PLANNING STATEMENT - ADDENDUM

SITE: 77 ALDWICK ROAD, BOGNOR REGIS, WEST SUSSEX, PO21 2NW

PROJECT: PART CHANGE OF USE OF GROUND FLOOR & FORMATION OF A FIRST FLOOR REAR EXTENSION TO CREATE 2 NO SELF-CONTAINED STUDIO FLATS WITH ASSOCIATED REFUSE / RECYCLING & CYCLE STORE (RE-SUBMISSION FOLLOWING BR/233/19/PL)

1357/P02 D

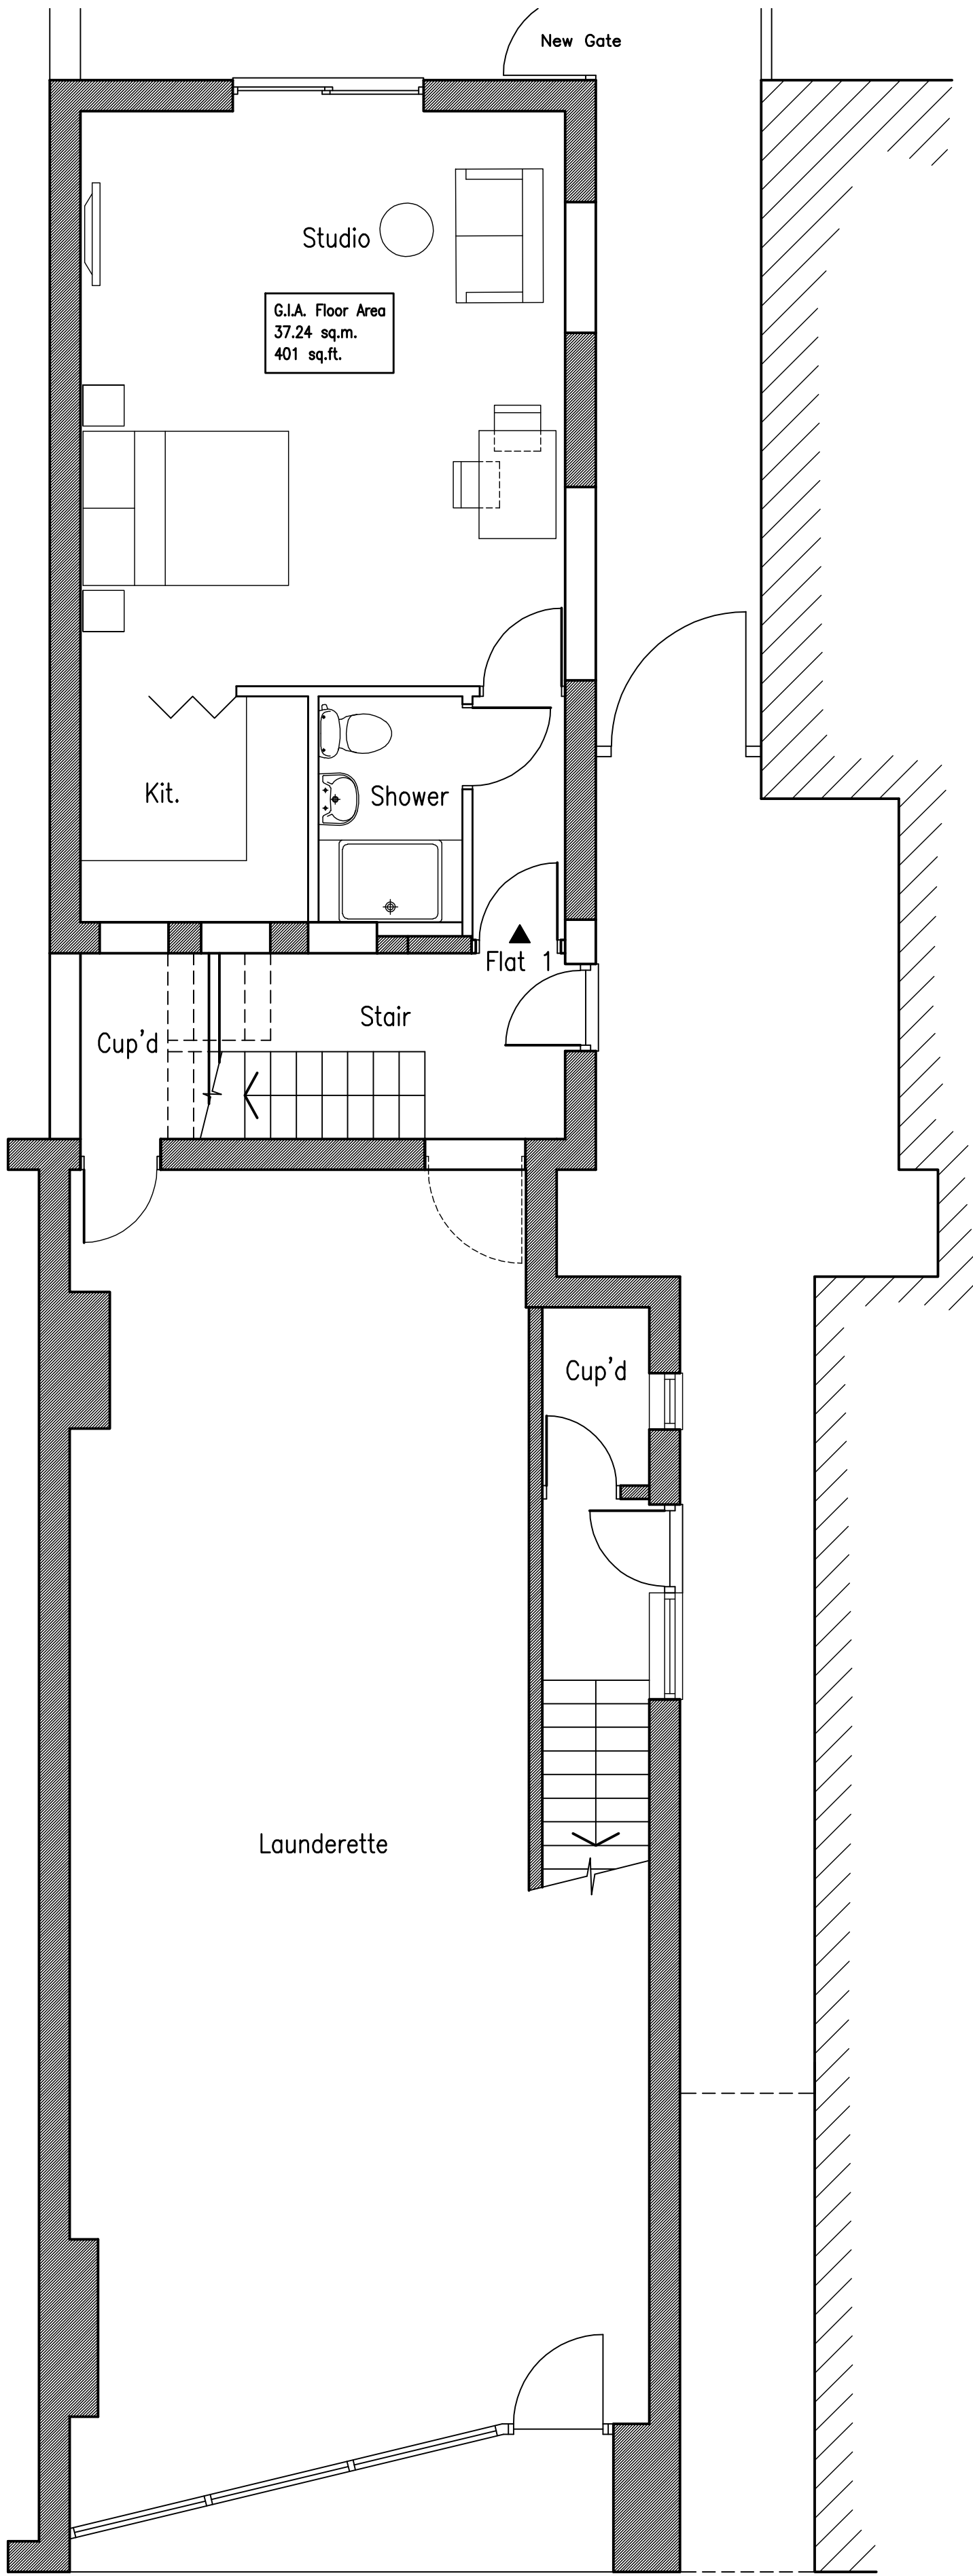
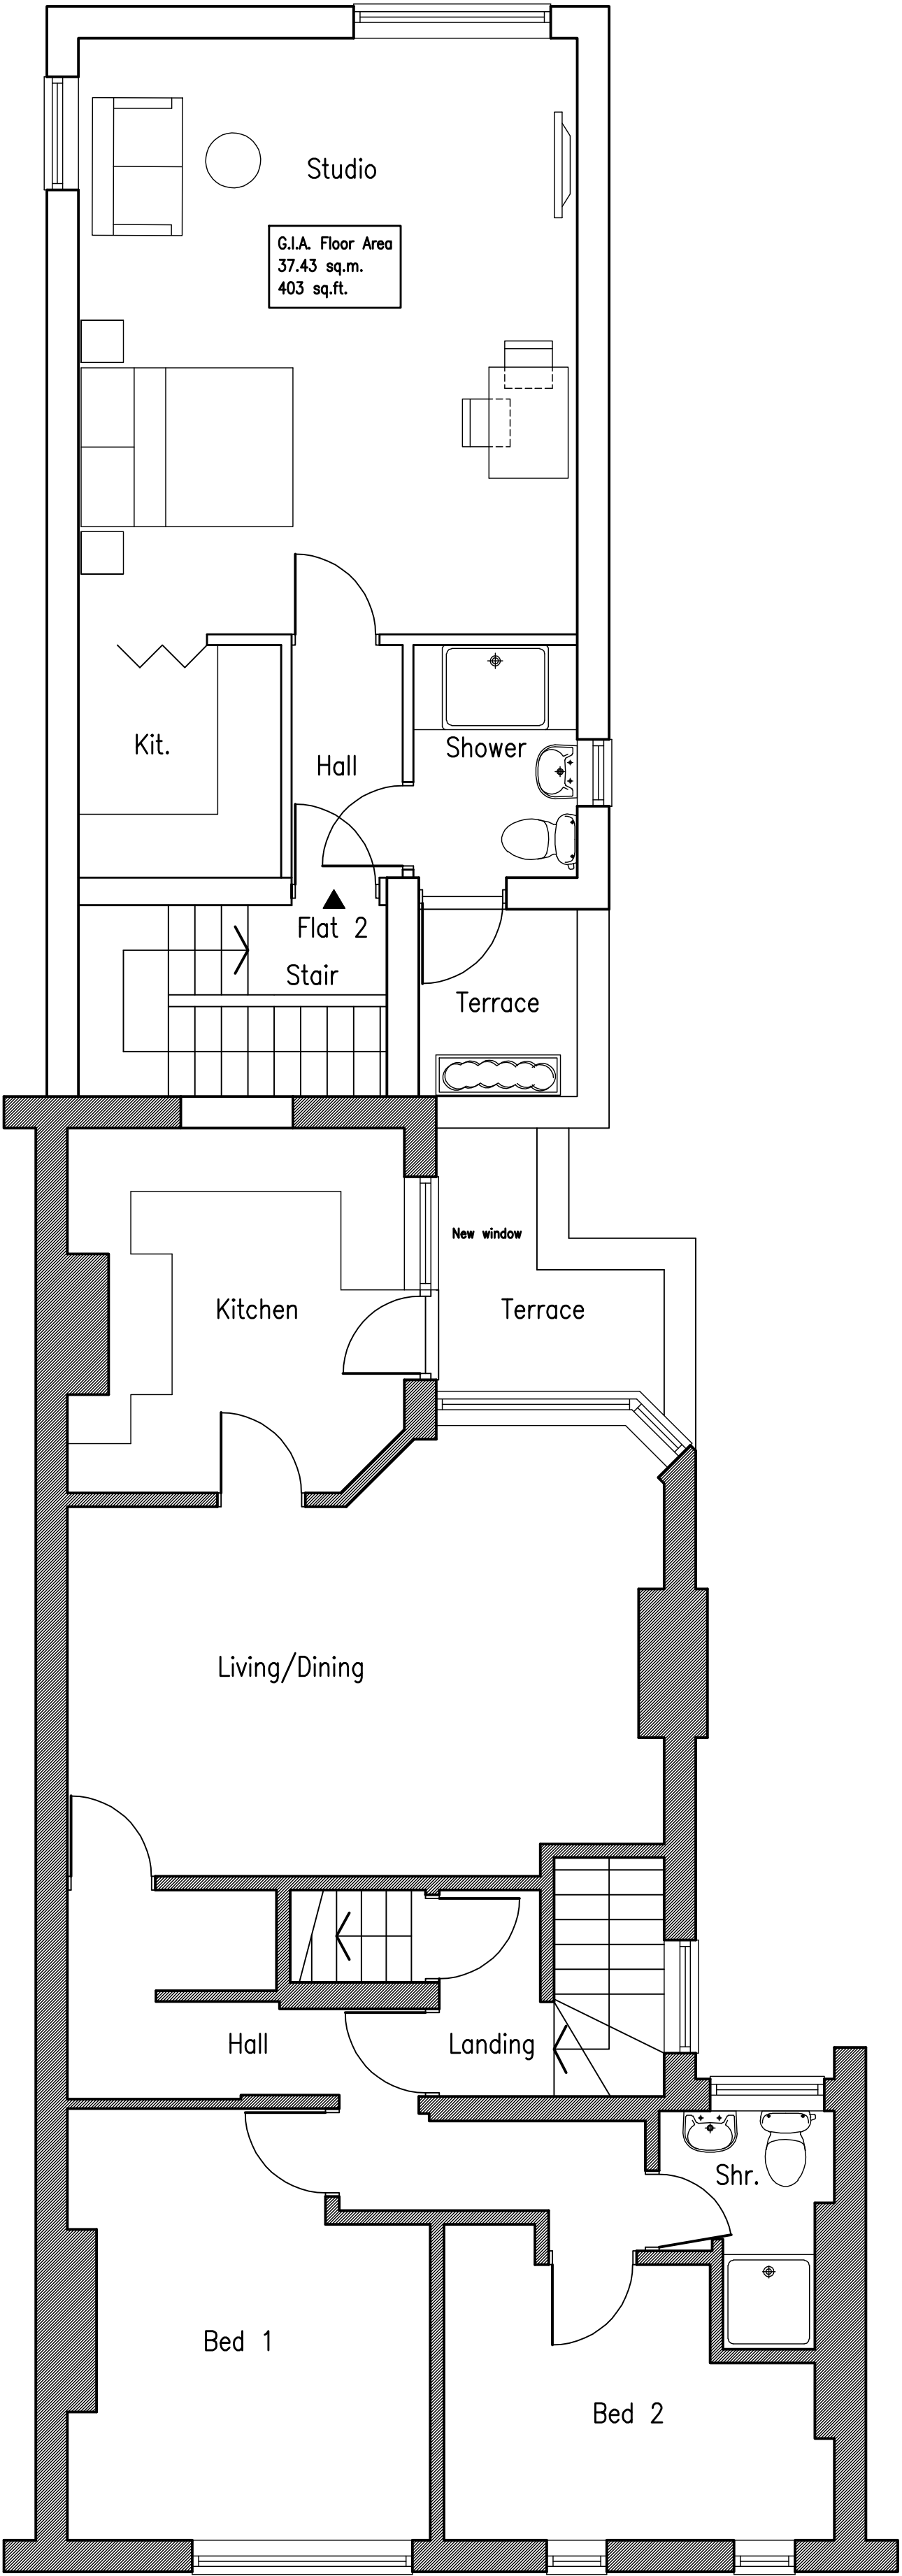
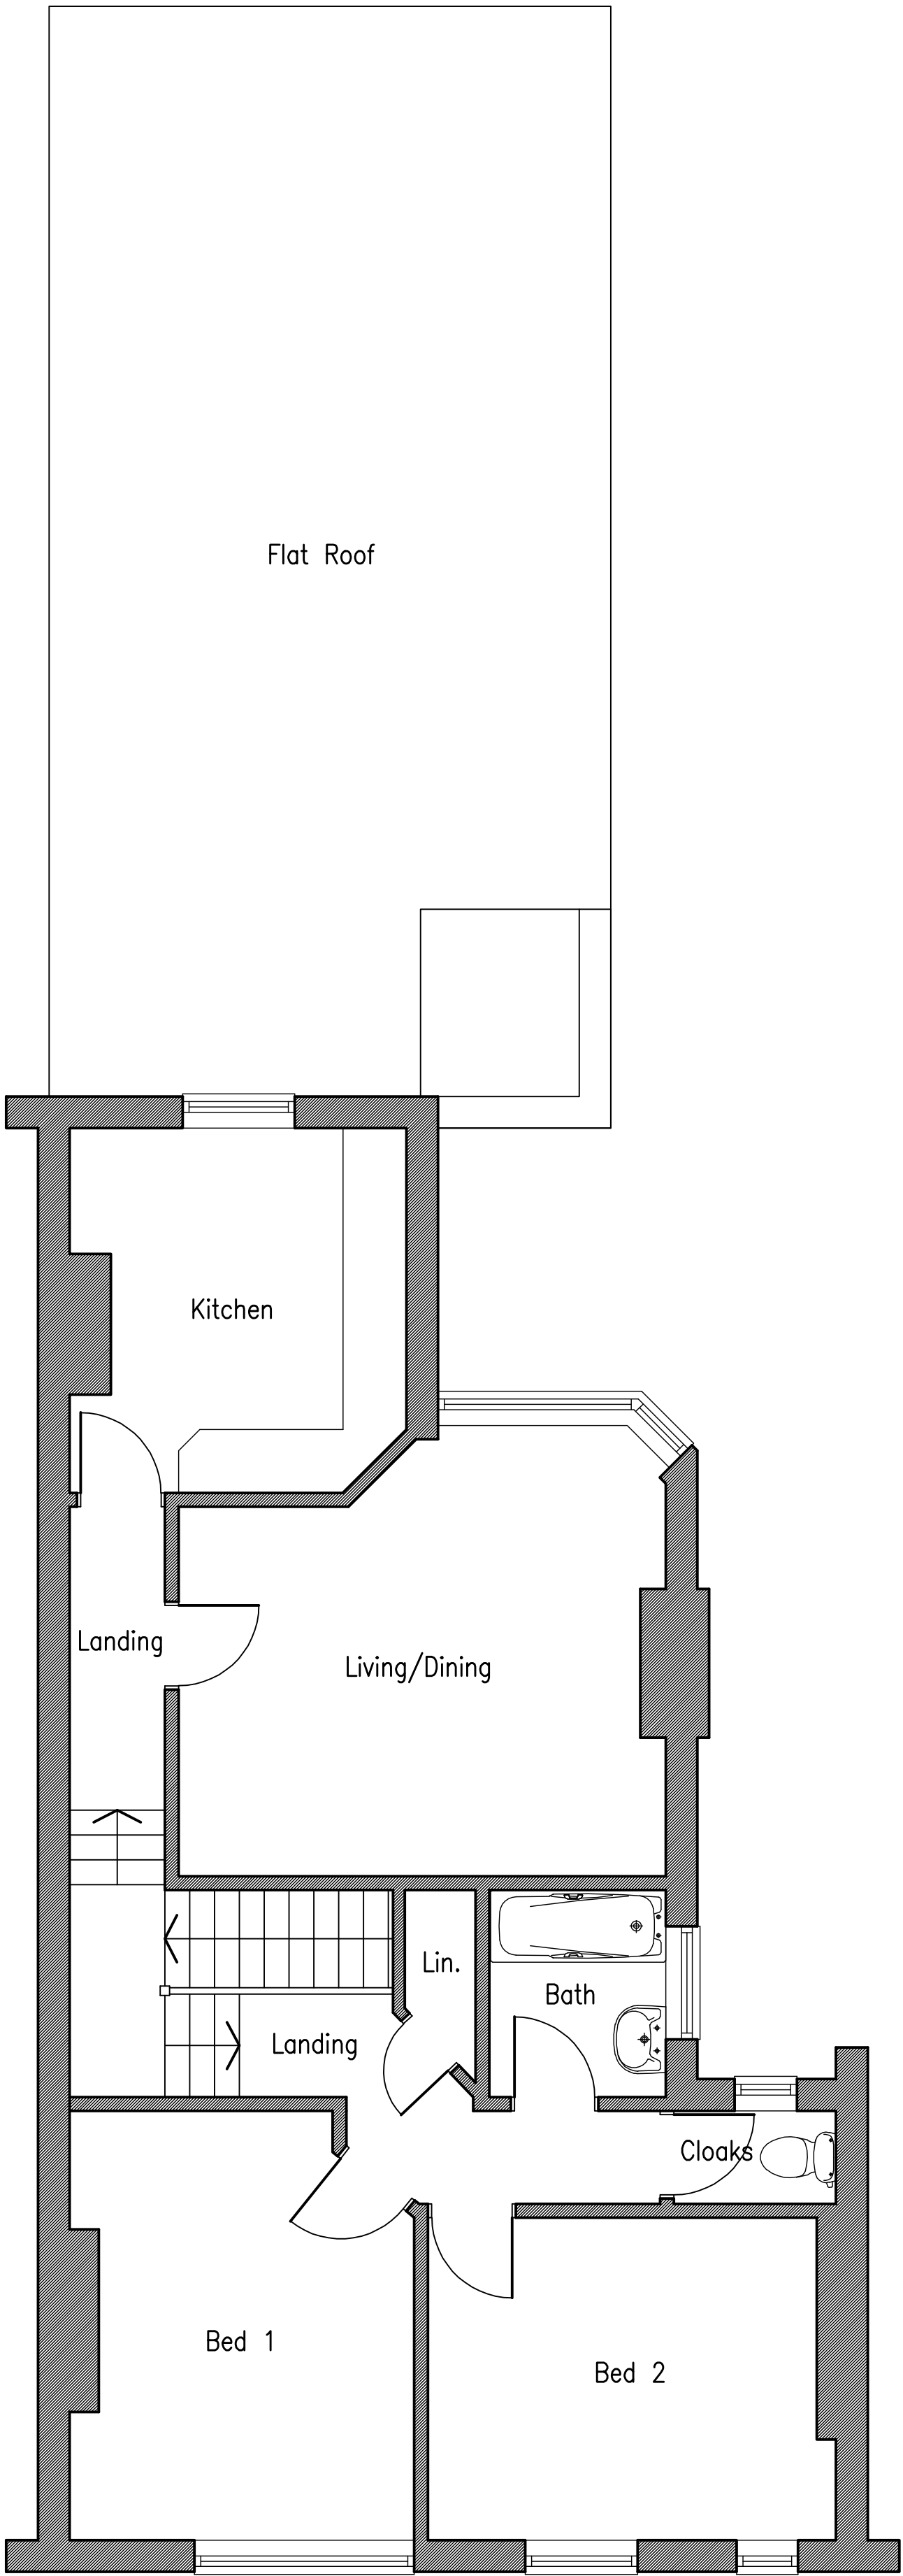
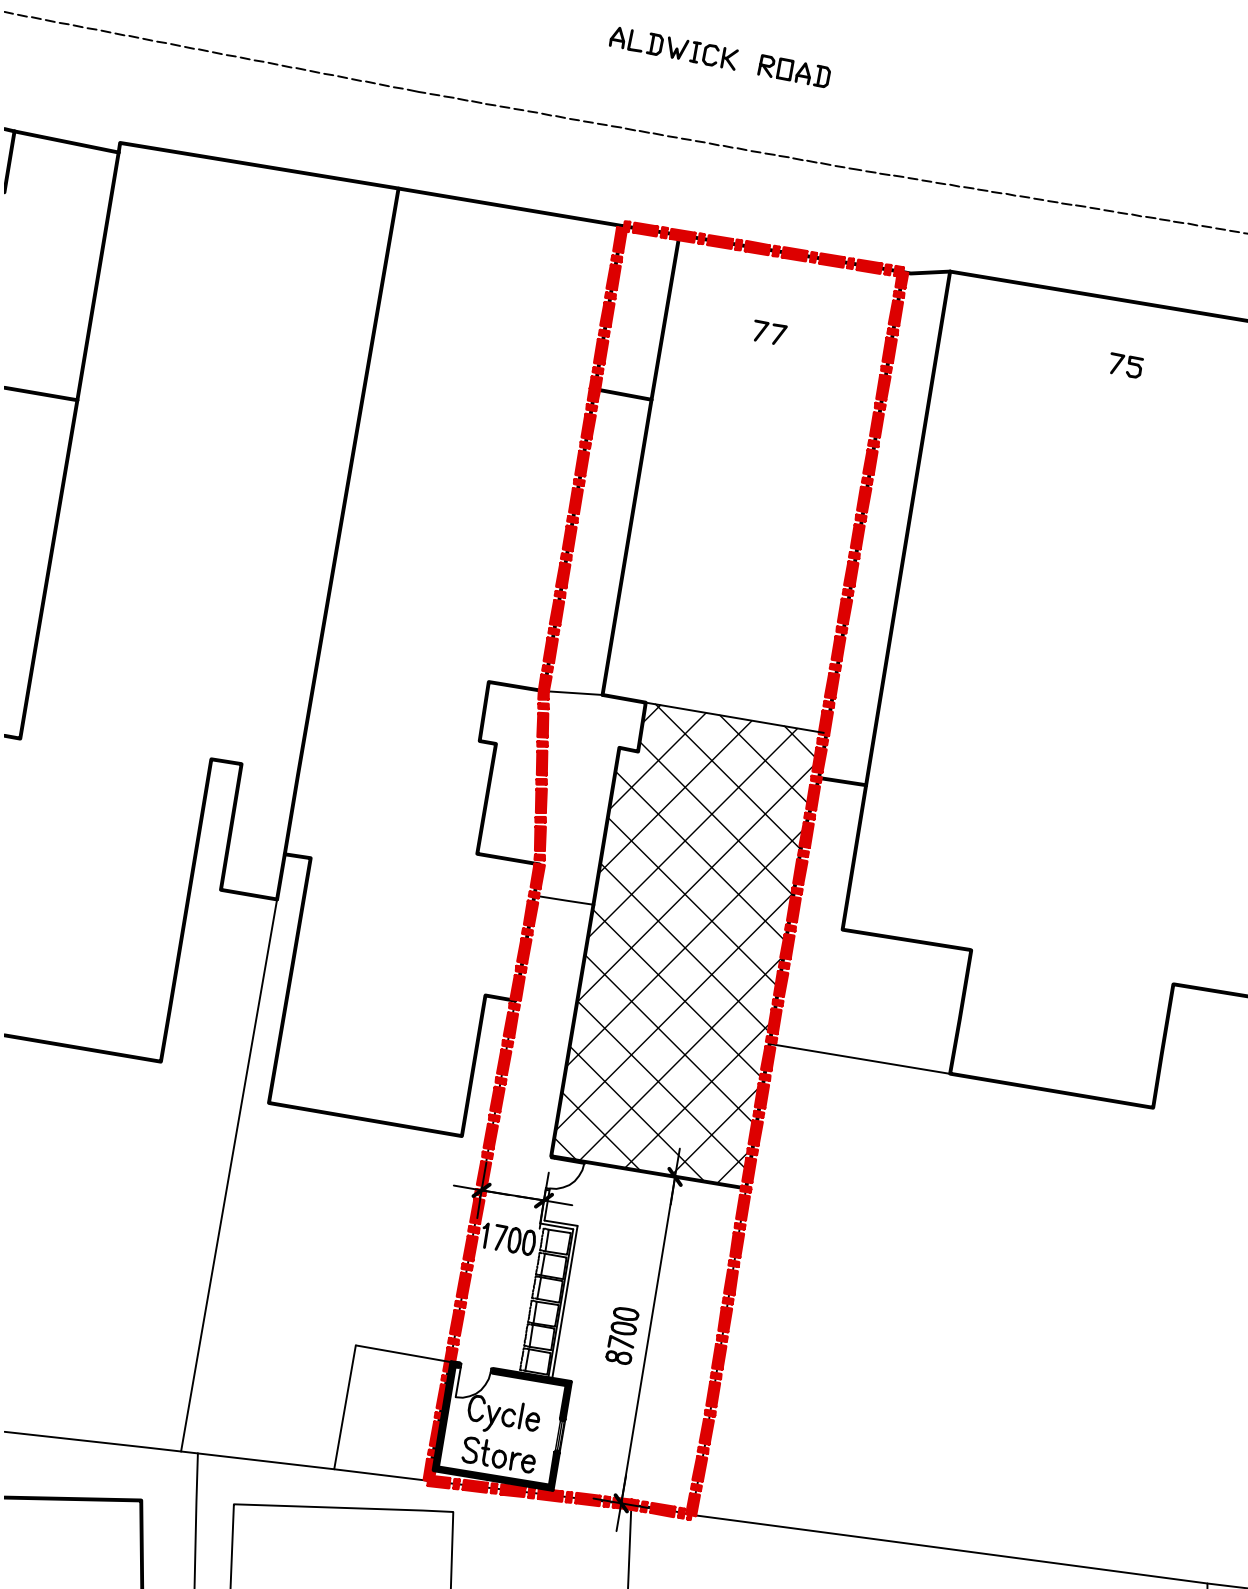
- 4.1.1 The amendments made to application ref BR/233/19/PL are essentially twofold: firstly, the proposed northern wall of the first floor extension would be positioned further to the south thereby opening up a greater gap to the host building; and secondly, the first floor window on the rear elevation will be re-sited further to the west and a new secondary window shall be opened up in the southern part of the eastern flank wall.

- 4.1.4 The re-positioning of the northern wall at first floor level to a position further southwards has had the effect of opening up a greater visual gap between the proposed extension and the host building. The change has been facilitated by the reversing of the configuration of the staircase in the 'link' between the proposed dwellings and the host building. The area that has been opened up between the existing terrace of no.77 and the new north wall of the proposed first floor dwelling will be occupied by a raised planted area accessed from the shower-room.

- 4.1.5 The height of the proposed first floor extension relative to the internal finished floor level of no.77 in the host building is 1.8m (the same as BR/233/19/PL), however now the northern wall of the proposed extension will now be positioned 4.6m from the window of no.77. Having in mind the fact that it was actually the windows of no.75 and 79 that were listed in the reason for refusal as suffering from an overbearing impact, the window to the latter is now over 6.0m away from the proposed extension. In view of the fact that this wall is only 1.8m high, it is

- 4.1.9 The proposed amendment has re-sited the window opening in the rear elevation to the far western side of the extension, thereby creating an even more oblique and more difficult view into the rear garden of 10 Stocker Road than would otherwise have existed under the previously refused scheme. In order to provide more daylight into the rear of the flat, and to provide additional scope for obscurely glazing the rear window in full or in part, a new secondary opening has been proposed at the southern end of the east facing flank elevation. This window opening would provide additional daylight and outlook for the proposed first floor dwelling and owing to the orientation of the window it would not overlook any neighbouring residential properties.
